**Consultation Response from KC,  
Highways Development Management**

**2025/90890 Land at, Yew Tree Road, Birchencliffe, Huddersfield, HD2 2EQ**

**Variation of conditions 1 (Plans), 2 (Materials), 6 (Landscape Works), 7 (Landscape Management Plan), and 14 (Ecological Design Strategy) of previous permission 2021/94363 for reserved matters application pursuant to outline permission 2018/90151 for erection of 17 dwellings**

**Date Responded: 29-4-2025.**

Refuse lorry - East to west

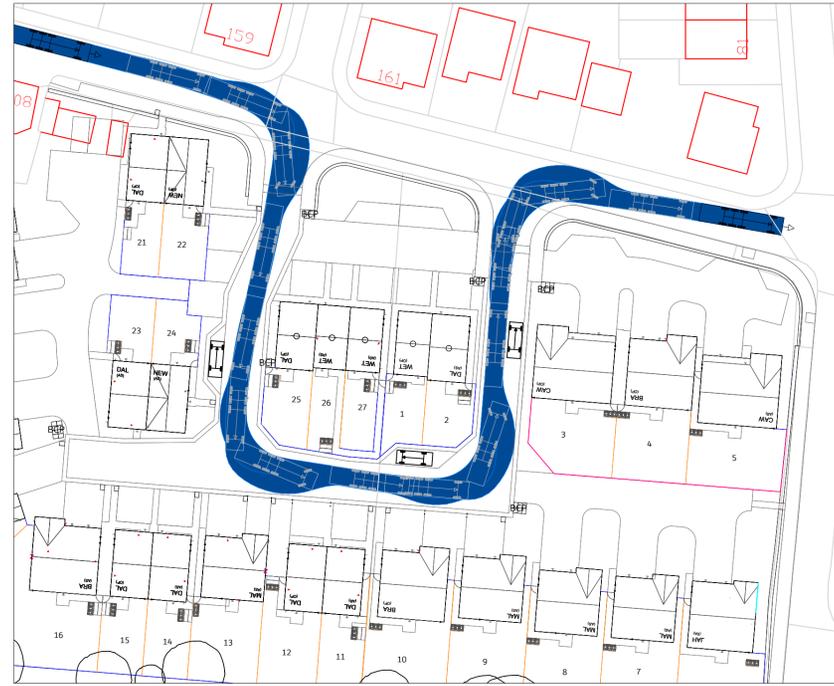
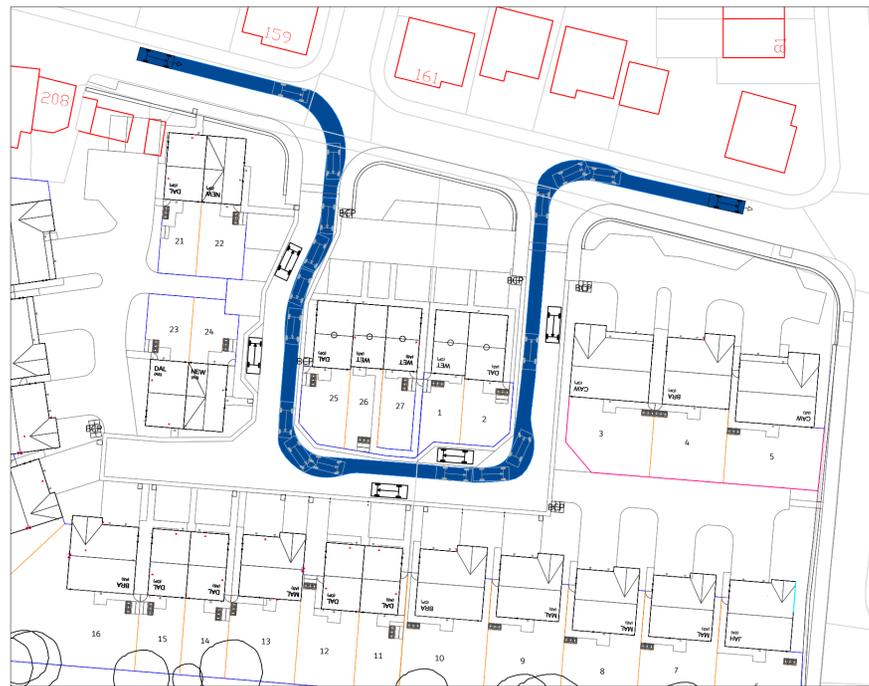
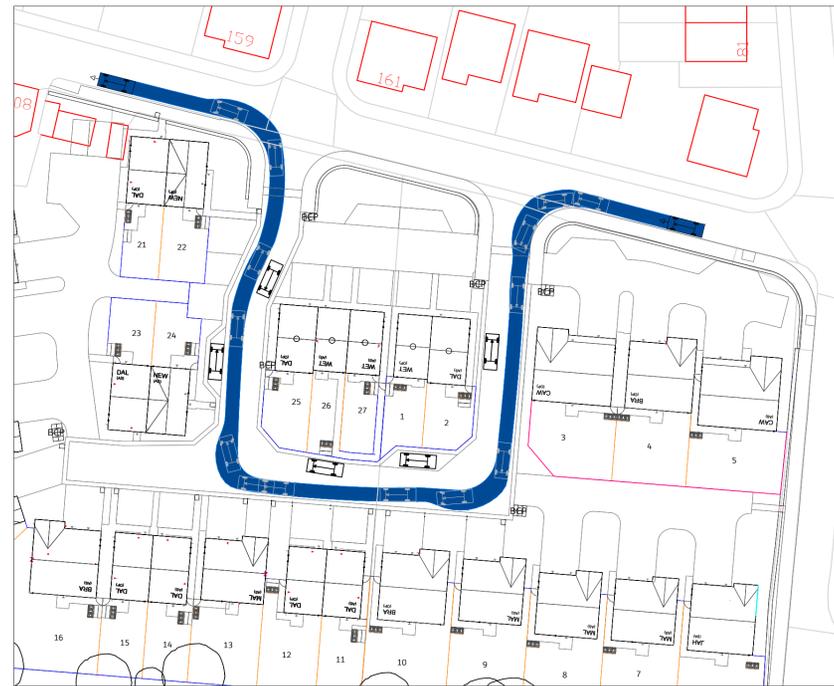
1, Given the layout is amended swept paths should be provided which demonstrate that an 11.85m refuse vehicle can enter and exit the site from Yew Tree Road and turn within the site. All schemes must incorporate reasonable tolerances and safety margins. A good starting point is to allow 0.5m clearance to kerbing or vertical obstructions on each side of the swept path. Designs should therefore, where possible, aim to cater for vehicles larger than the above minimum standards.

3, Only 2 visitor parking spaces are shown, 4 spaces are needed to meet recommended standards. If on street visitor parking is proposed the swept path vehicle tracking should show the parking will not obstruct the refuse vehicle at all feasible locations
